Your ref:	Bershka - 221 to 223 Oxford S...	Please reply to:	Mr Gregor Gault
Our ref:	24/00885/ADV	Tel No:	
		Fee Queries:	0207 641 6500;
		Email:	planningreception@westminster.gov.uk;
Mrs Lucy Palac Deploy Project Services 28 The Ridgeway Tonbridge TN10 4NH United Kingdom		Incomplete Applications Town Planning & Building Control City of Westminster PO Box 732 Redhill, RH1 9FL	
		14 February 2024

Address: Alexandra House, 221-223 Oxford Street, London, W1D 2LJ,

**Proposal: Display of an internally illuminated fascia sign measuring 40cm x 280cm;
 and an internally illuminated projecting sign measuring 40cm x 93cm.**

PROYECTO	CASTEL Estudio	FECHA	1:50
PROYECTANTE	CASTEL Estudio	ESCALA	1:50
TÍTULO	FACHADA CALLE 2D	FECHA	26/01/2024
PROYECTANTE	F3/ V03	FECHA	26/01/2024

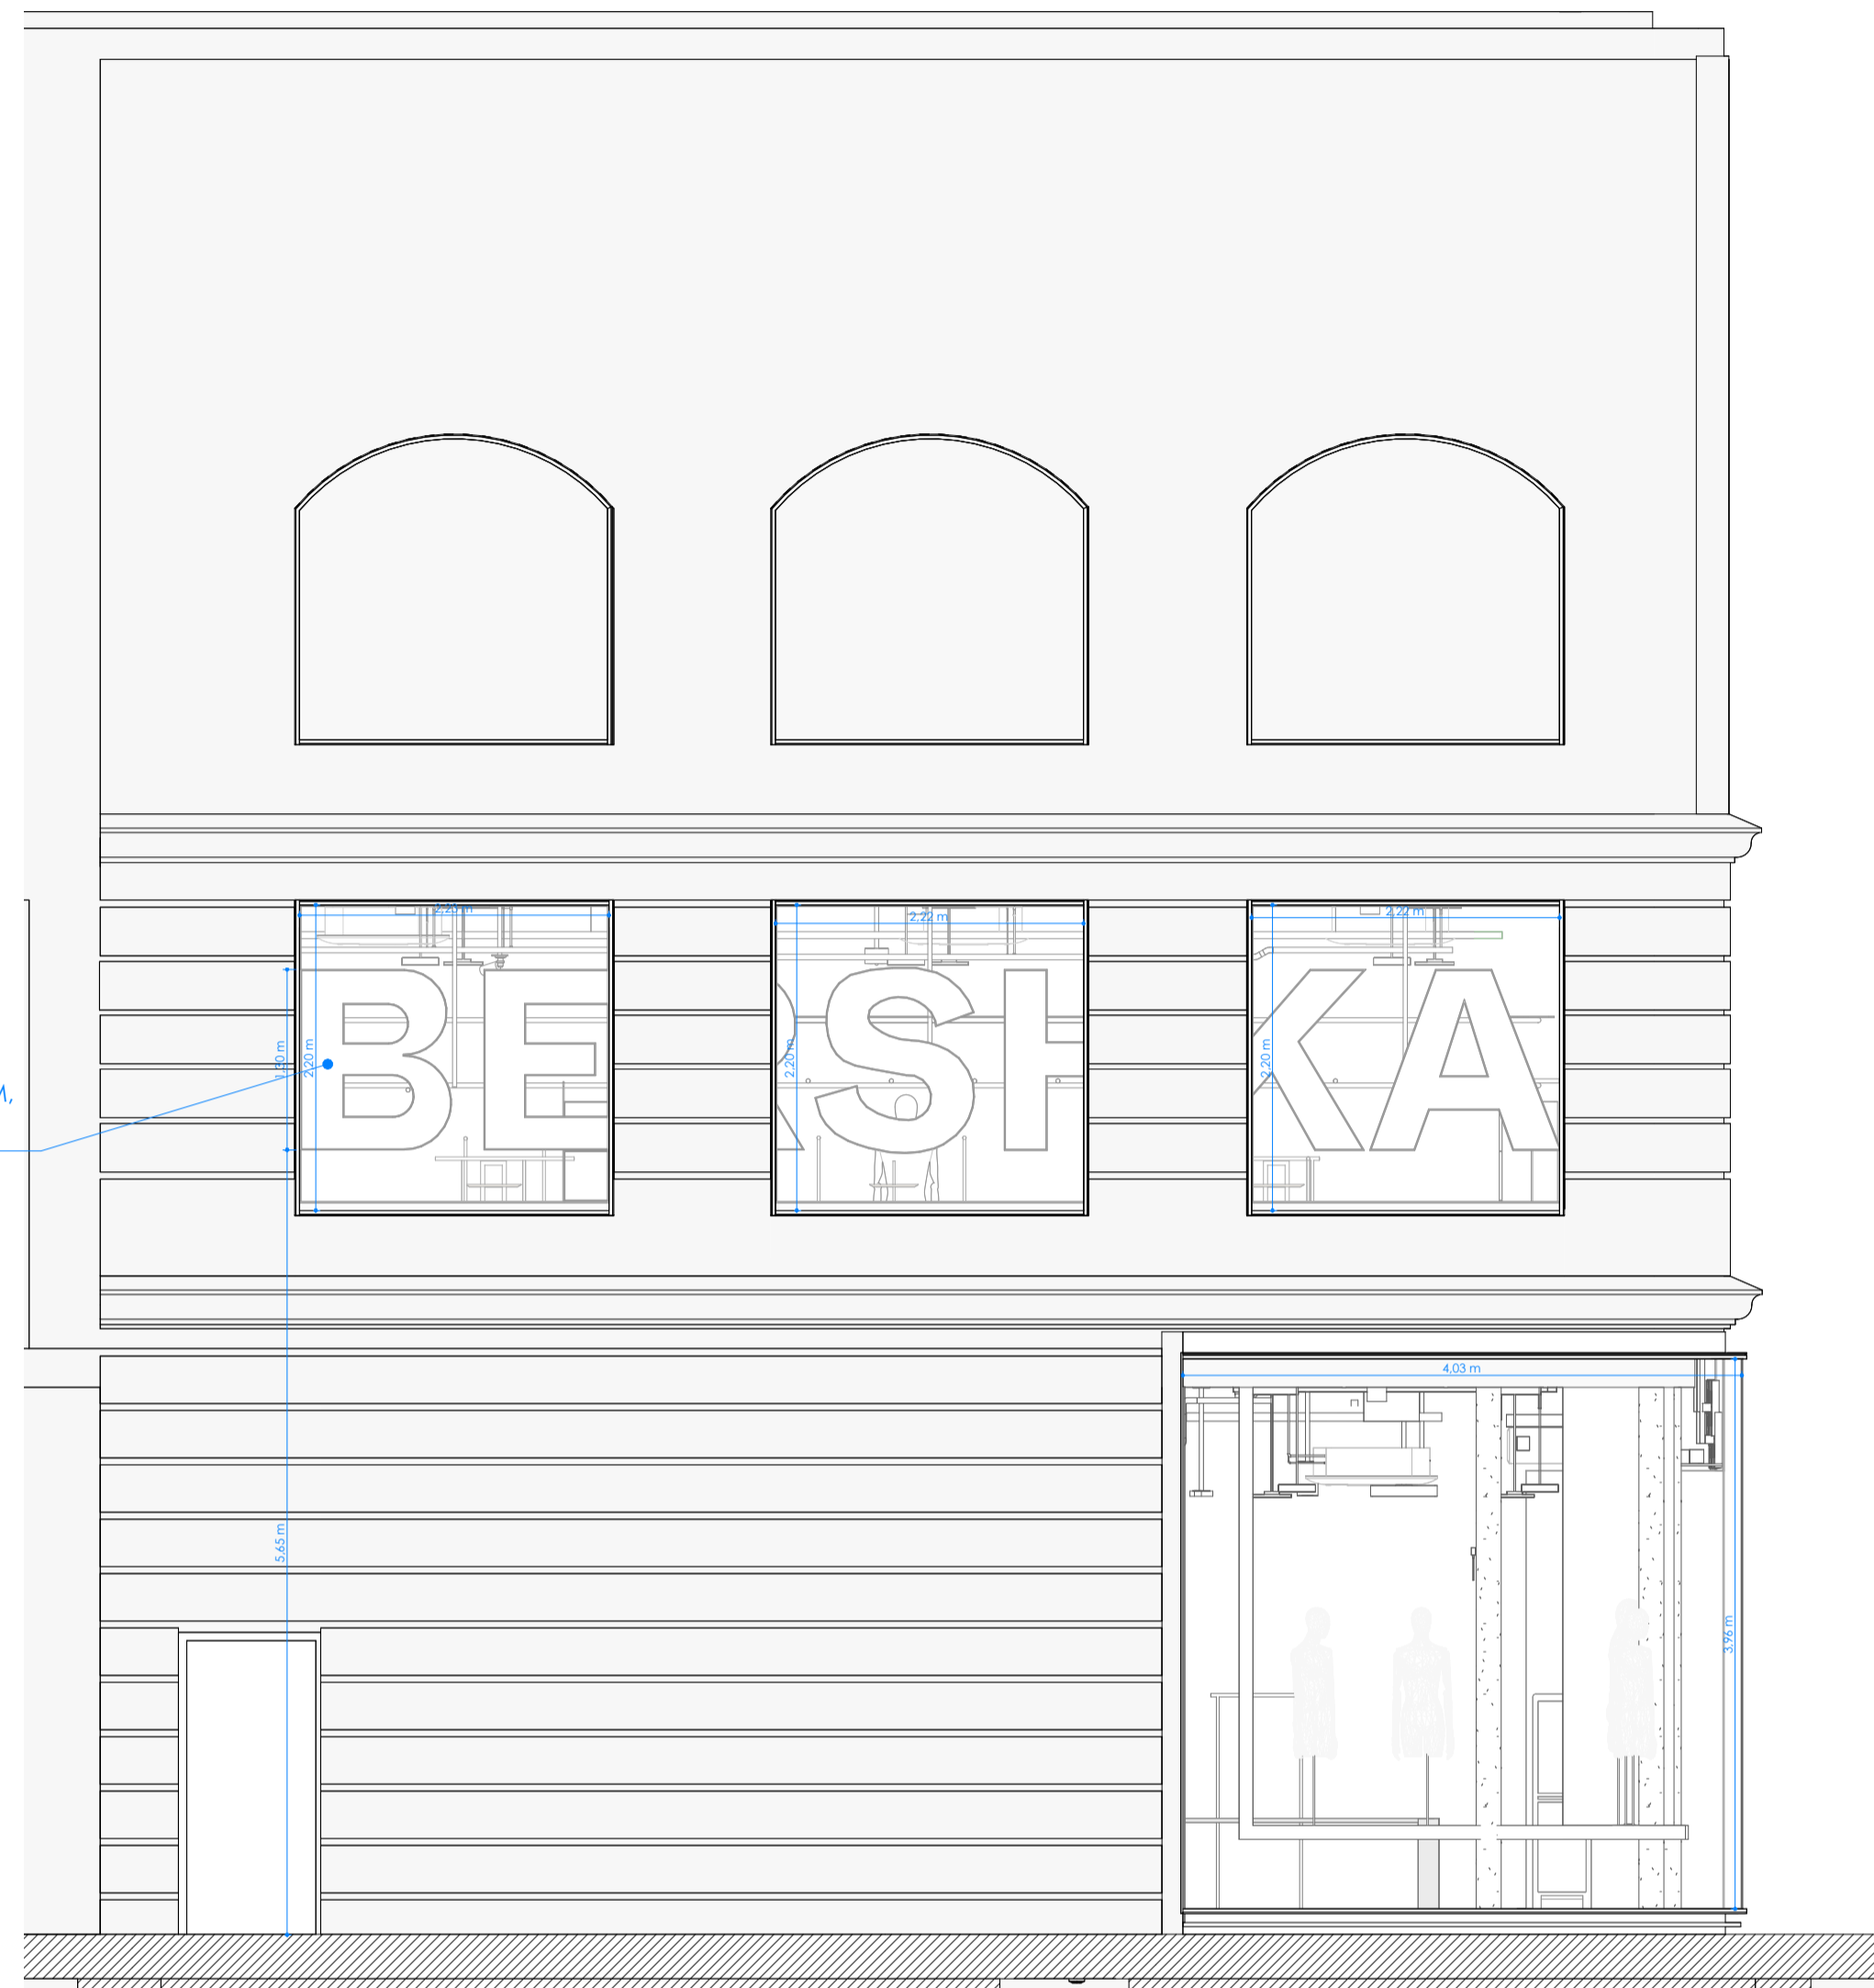
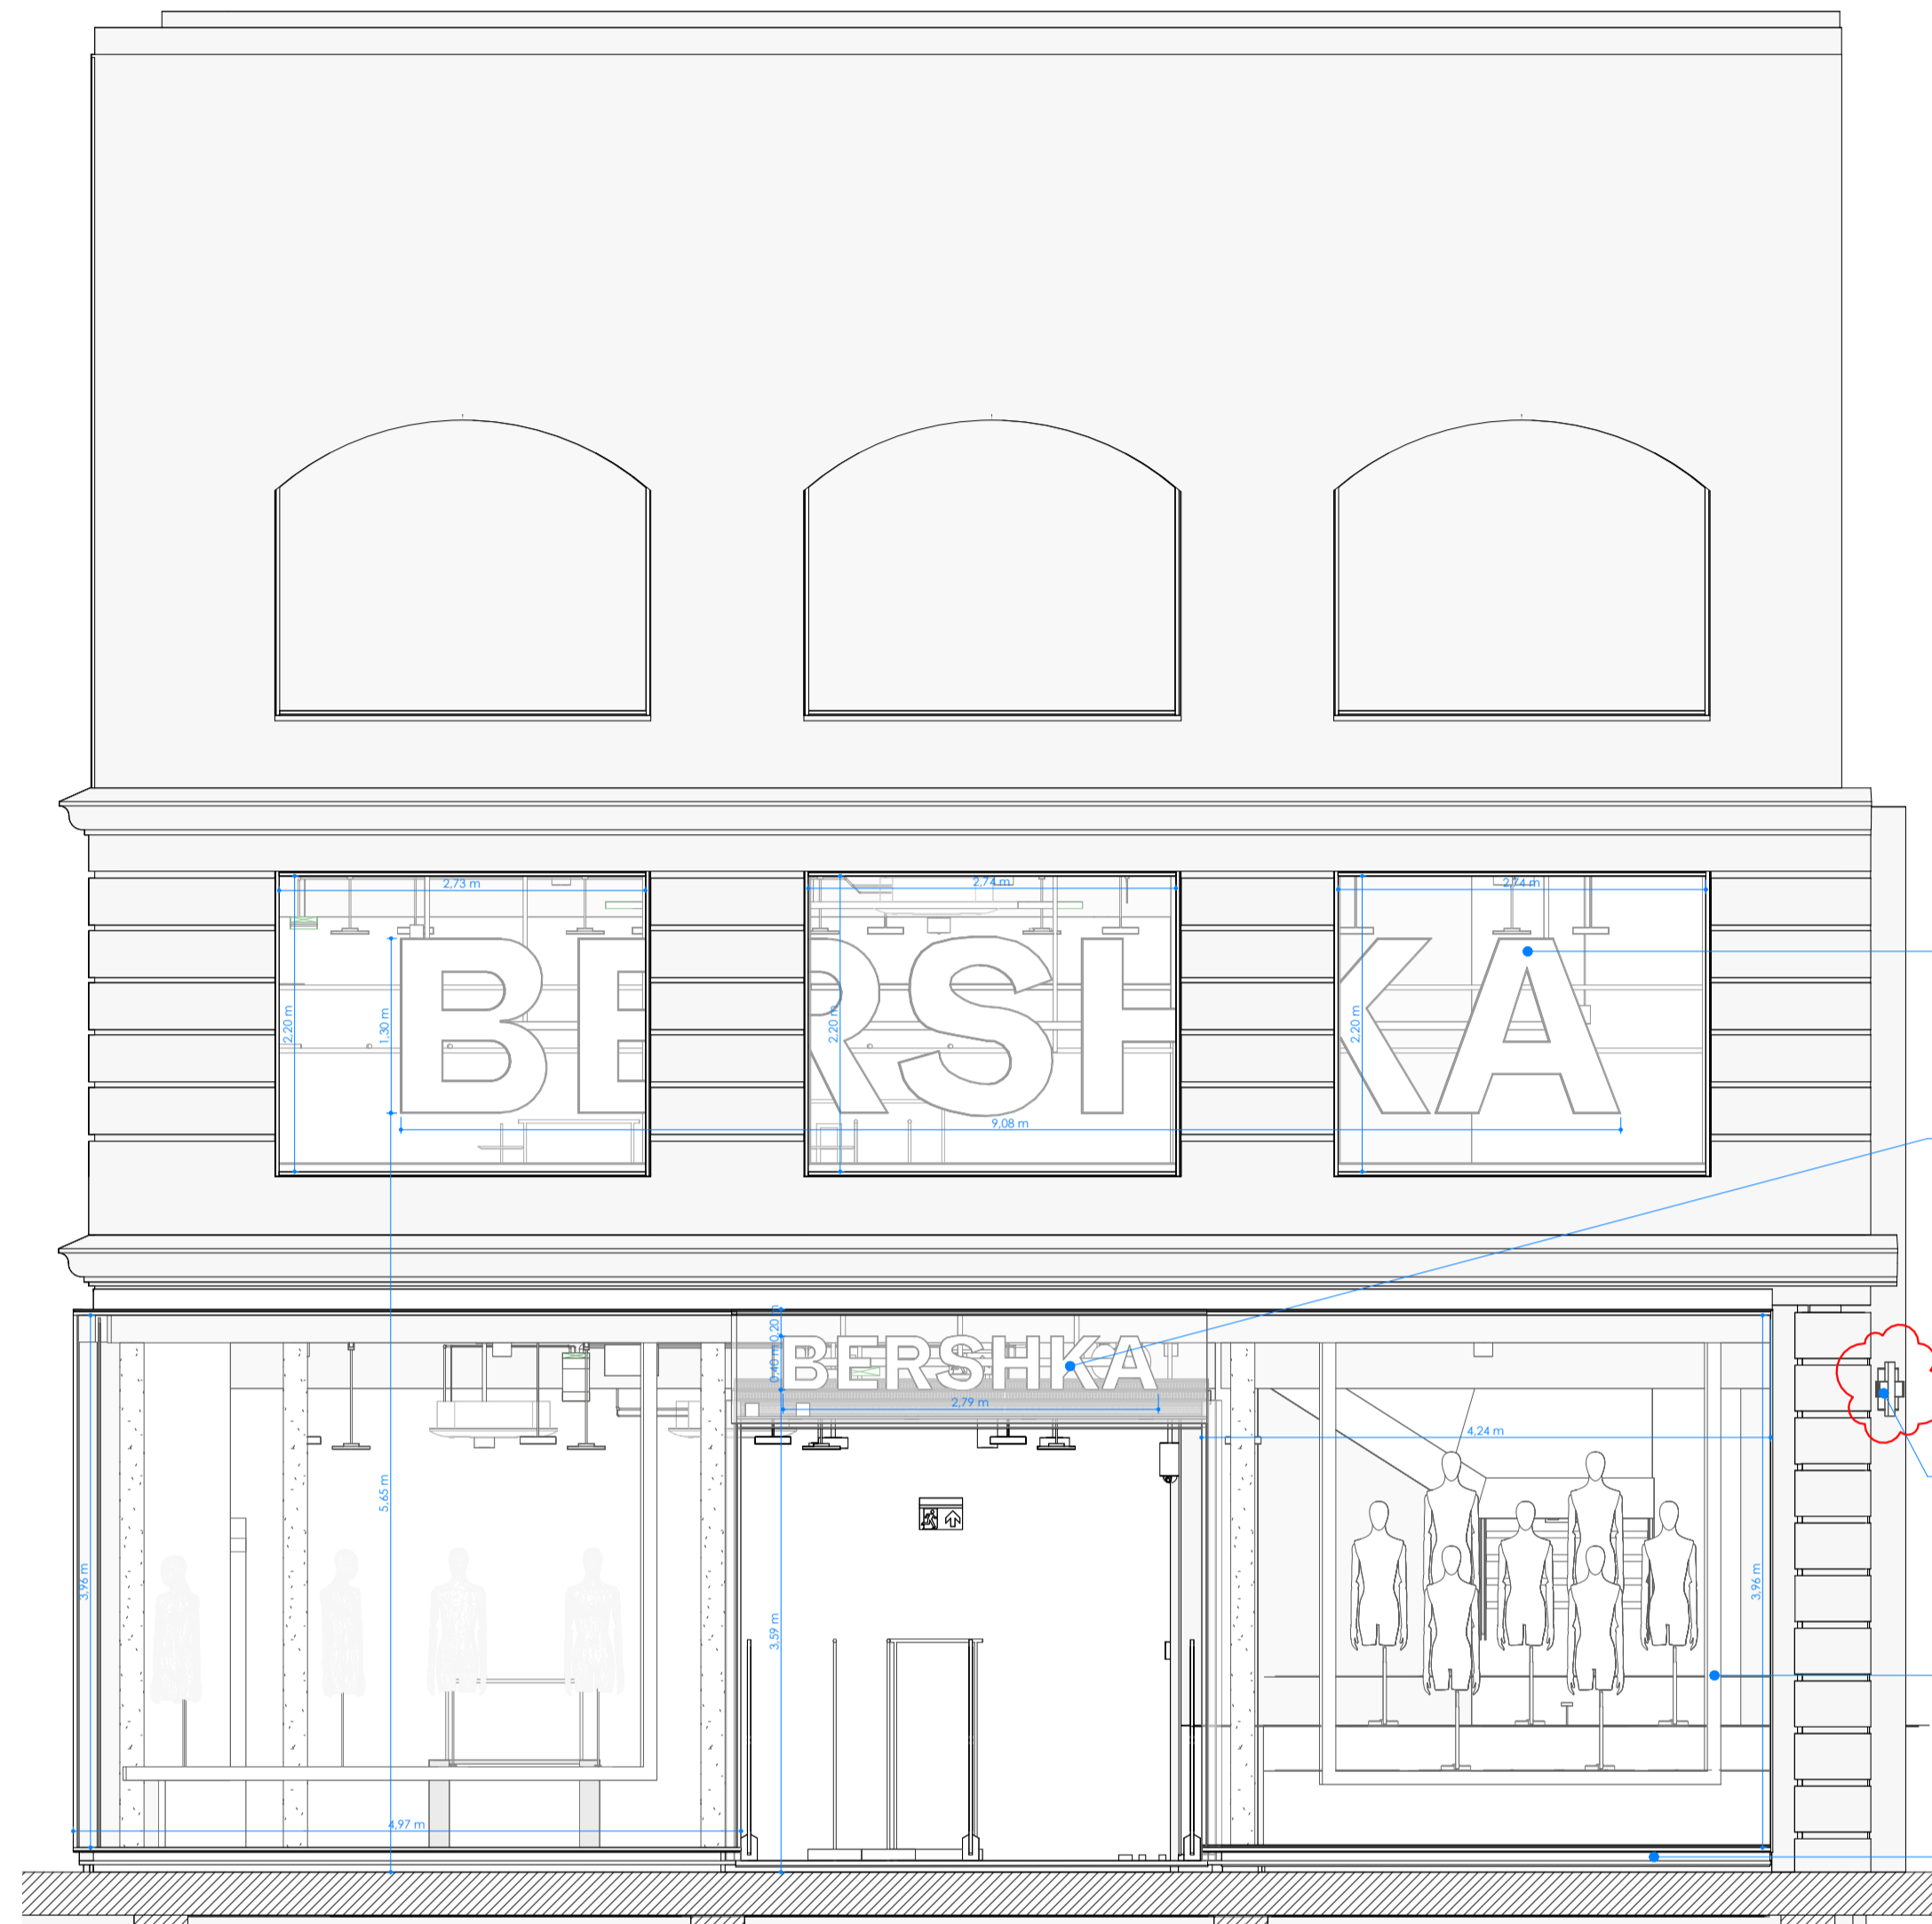
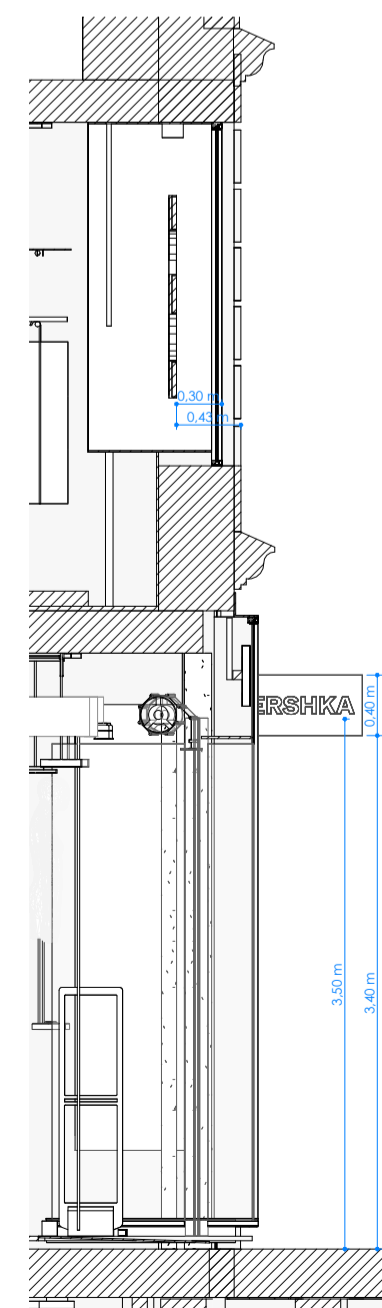
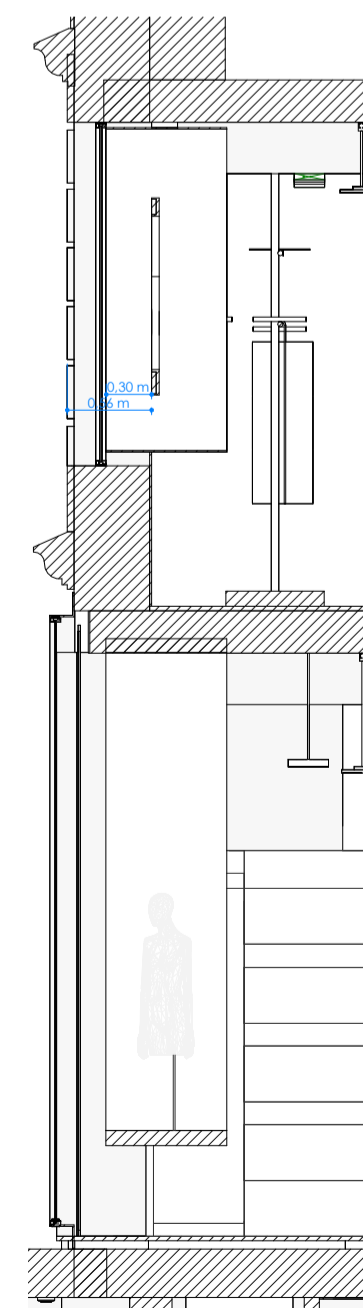
1 Please provide detailed section drawings of both the proposed fascia and projecting signs that clearly show the methods of internal illumination.
